From: Simon Davis
Sent: 14 August 2020 15:08
To: Clare Bartlett [REDACTED]
Cc: Daniel Vick <Daniel.Vick@arun.gov.uk>
Subject: RE: AL/49/20/PL Byfields & Nightingale Cottage

From: Simon Davis <Simon.Davis@arun.gov.uk>
Sent: 11 August 2020 14:56
To: Clare Bartlett [REDACTED]
Subject: AL/49/20/PL Byfields & Nightingale Cottage - Design & Highways

Tree Retention Protection Plan Byfields and Nightingale Lodge, Aldingbourne, West Sussex

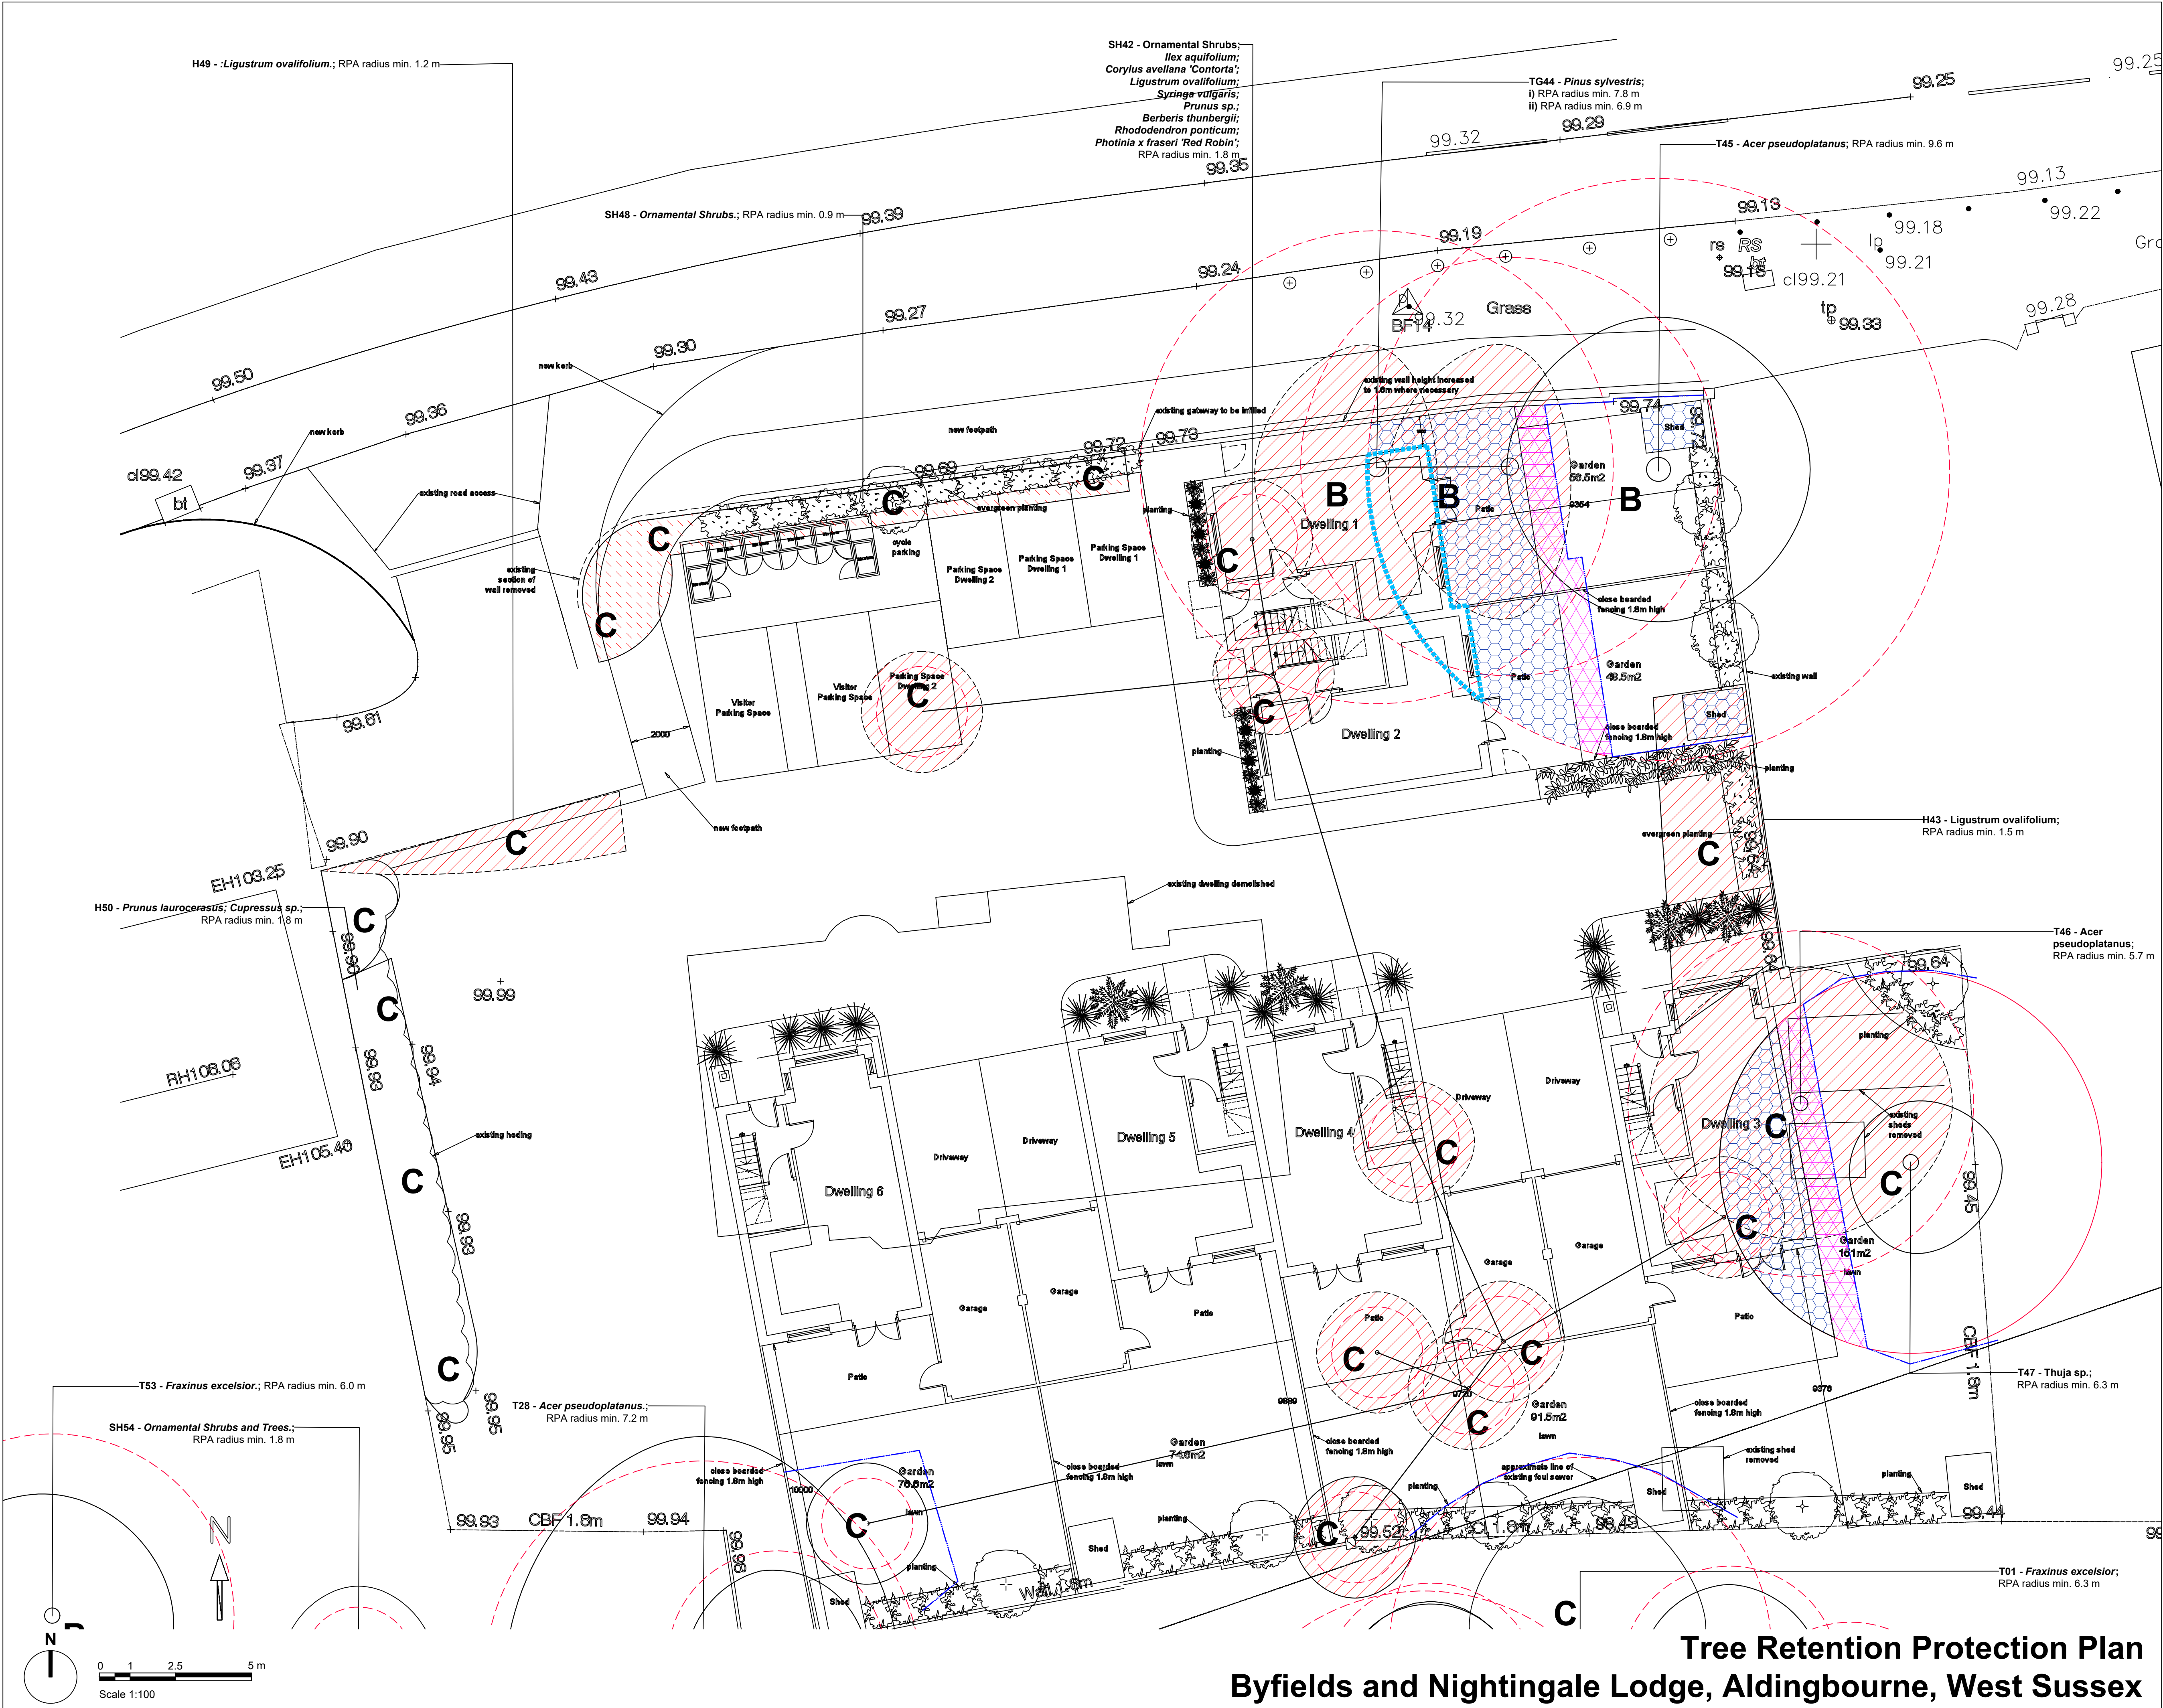
- The site is very much of an urban/rural edge character and the proposals do not reflect this character.
- The elements that make up the character of this site – boundary wall, grass verge, landscaping, spacing will all be destroyed as a result of the proposals.
- The design is poor and does not appear to be based on local character/context. Either side of the site are dwellings with a relatively strong character, yet what is proposed is at odds with that.
- Surrounding dwellings are predominantly 1.5 storeys yet these are 2.5.
- The trees on the frontage should be respected & retained.
- There may be a scheme here but definitely not 6 dwellings.

The vast majority of existing landscaping will also be retained and for every tree removed two will be planted in its place so there will be an increase in landscaping.

These are not Category A trees and overall the scheme replaces each lost tree with two.
